# CITY OF ALBUQUERQUE

October 20, 2020

**Re: WAQ1 Delivery Station  
7300 Meridian PI NW  
Traffic Impact Study  
Dated October 2020 (HT#J1D002G1)**

Driveway (access) Locations

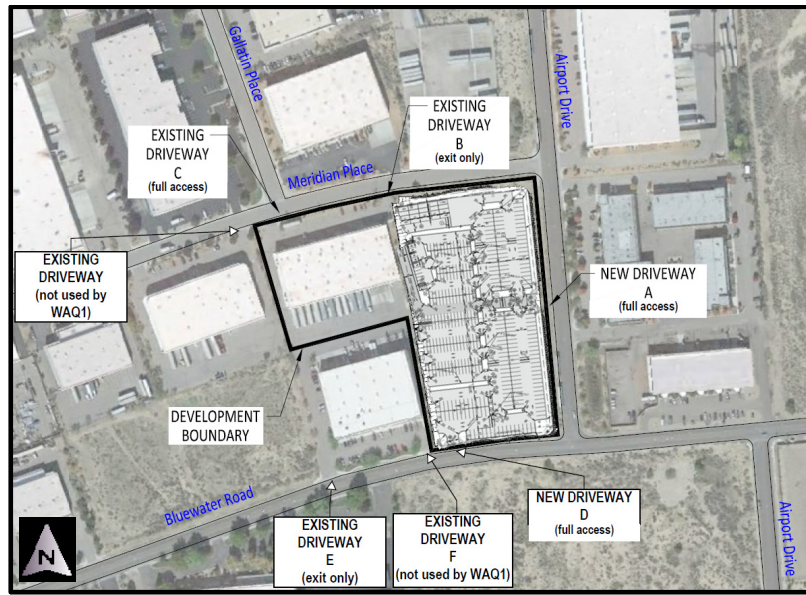
1. Driveway D will need to be designed further east to maintain a required 100 foot spacing from existing Driveway F while also maintaining 100 foot spacing from the Airport Drive/Bluewater intersection.
2. Design and construction of the proposed WAQ1 Delivery Station shall maintain adequate sight distances at proposed driveways.
